TO: Lindsey Ozbolt
FROM: Christina Wollman, Planner III *CW*
DATE: November 2, 2015
SUBJECT: Wheatley CU-15-00003

The Department of Public Works has reviewed the permit for the Wheatley Conditional Use Permit and has the following comments:

# Plat Plan Daycare Facility For Toni Stroescher

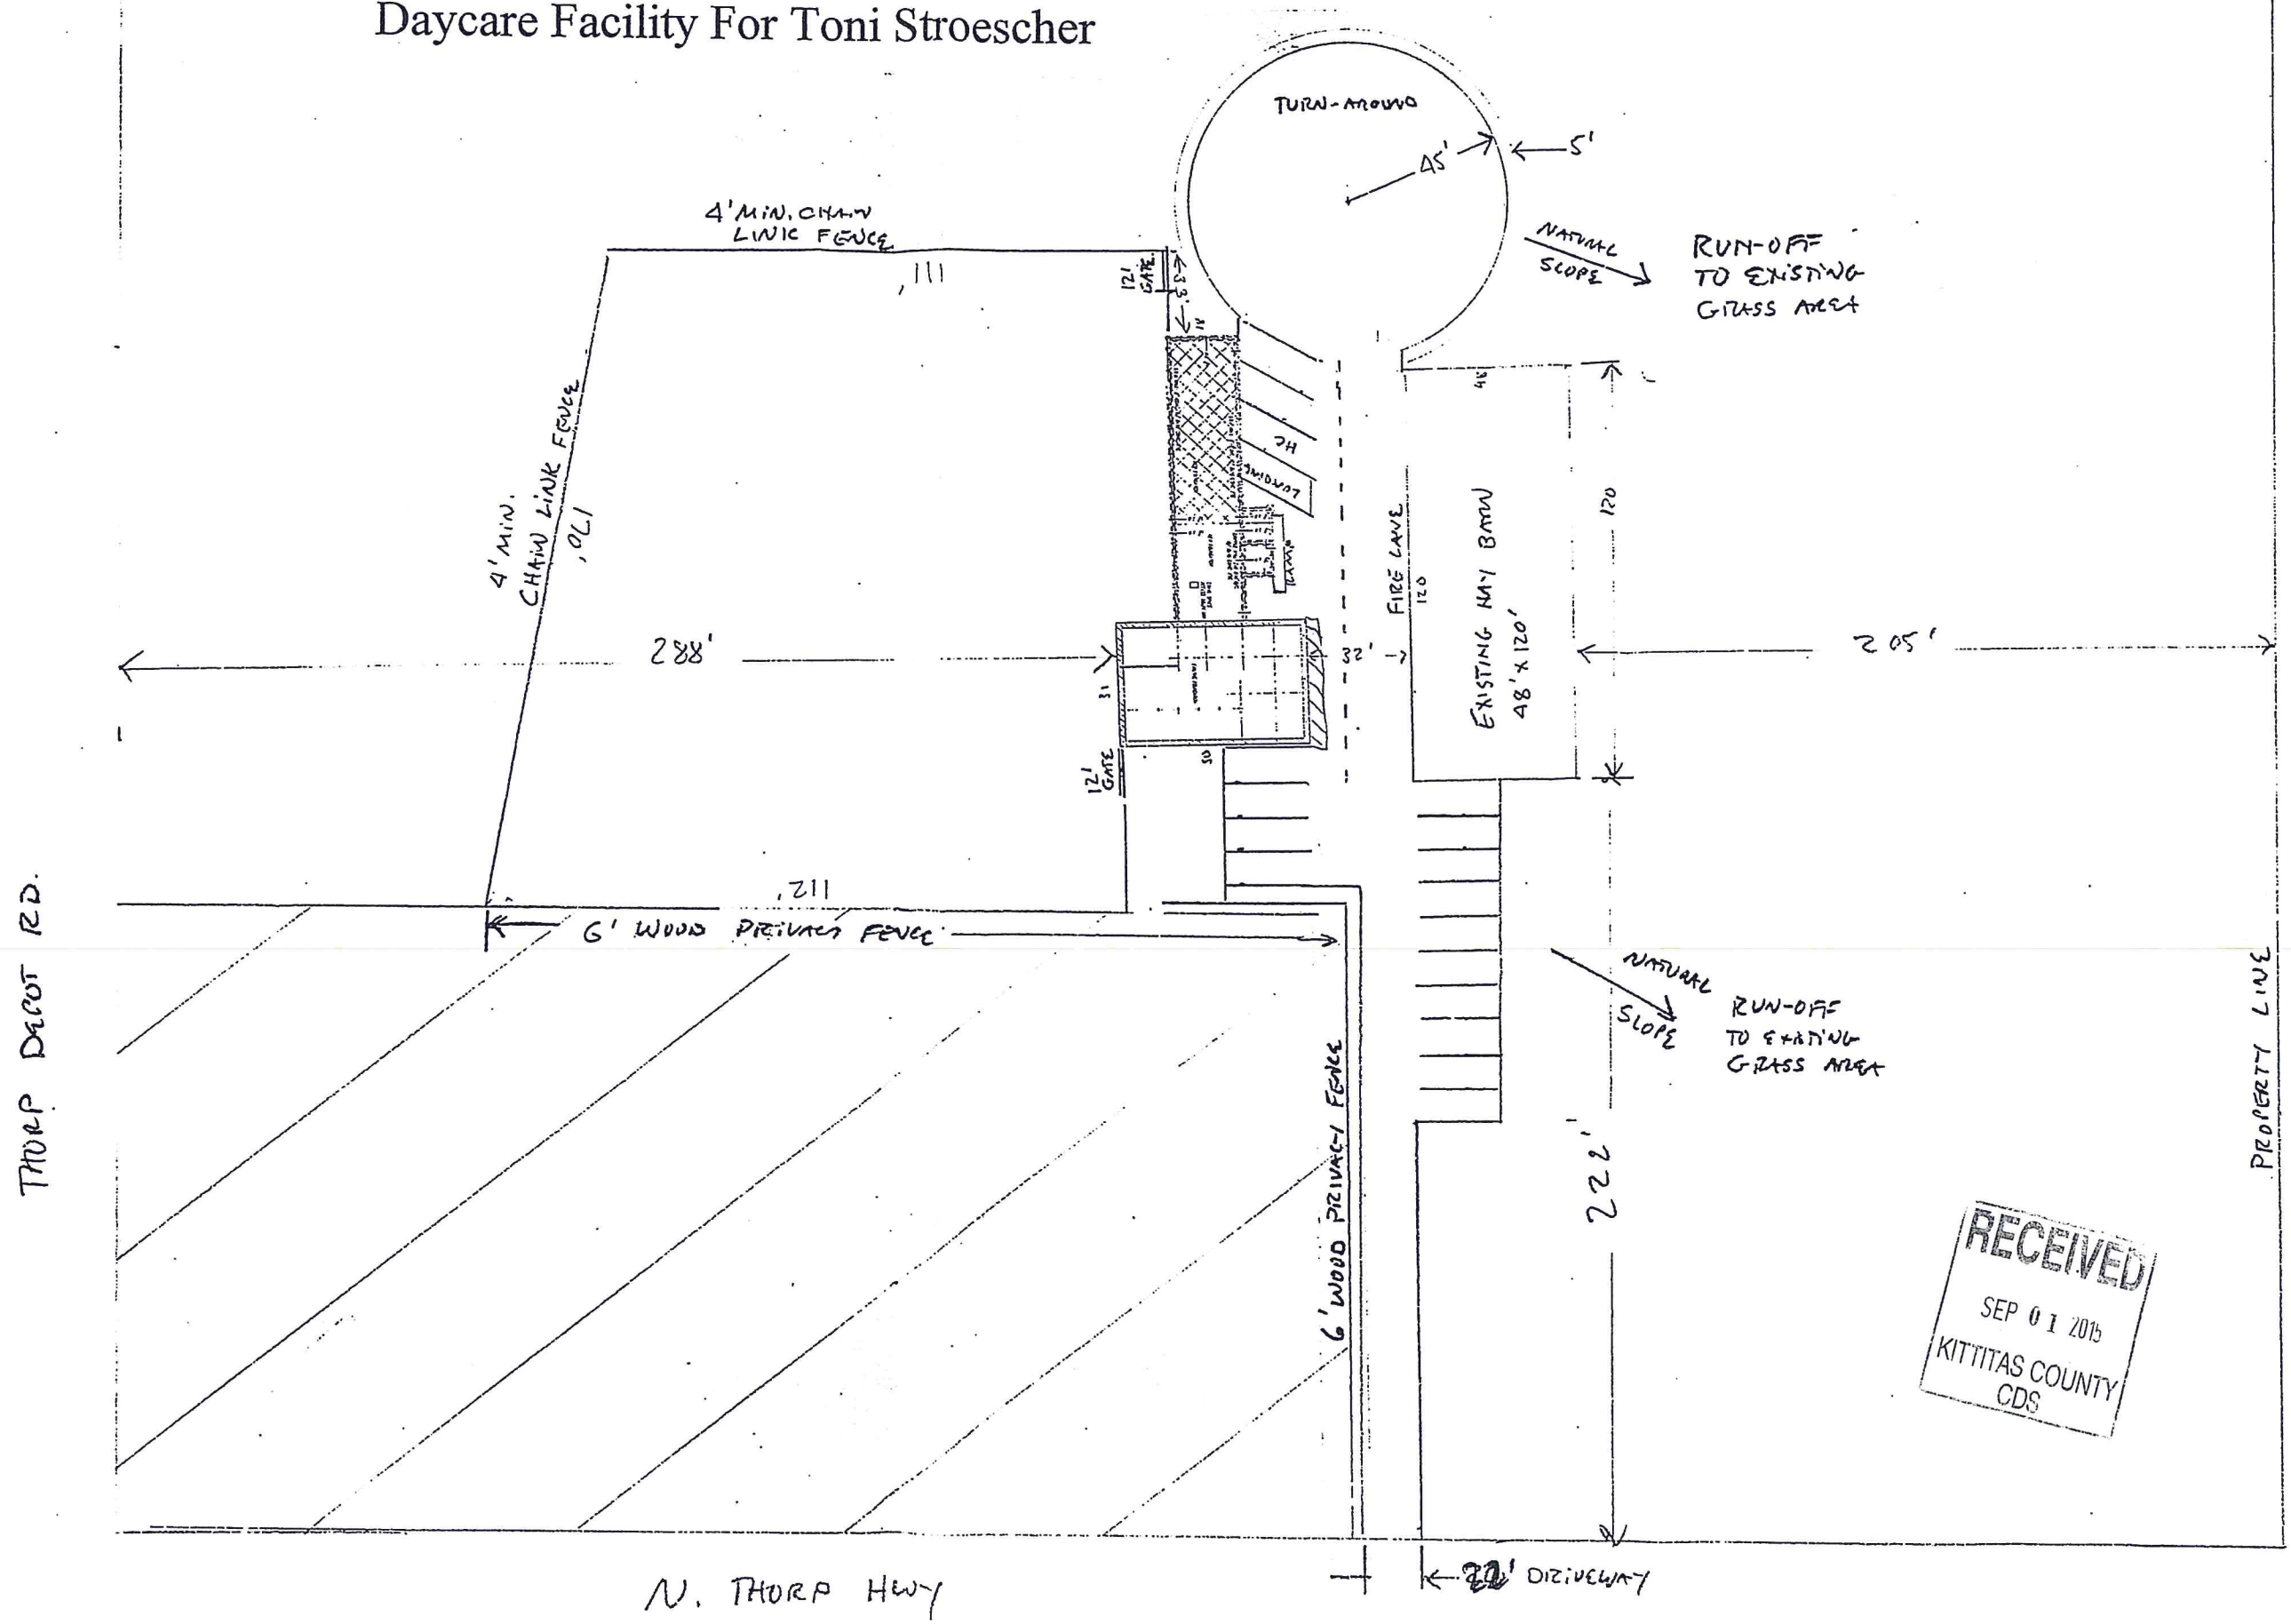
- A. Transportation Concurrency: A Determination of Concurrency Finding has been issued for this project under number TC-15-00009. No mitigation is required of this project.
- B. Site Access: The driveway must be constructed to commercial standards, as shown in the WSDOT Design Manual Exhibits 1340-1 and 1340-2. Please contact Kelly Bacon at 509-962-7523 to discuss the requirements and the existing paved apron. A Kittitas County Access Permit is required prior to driveway construction.
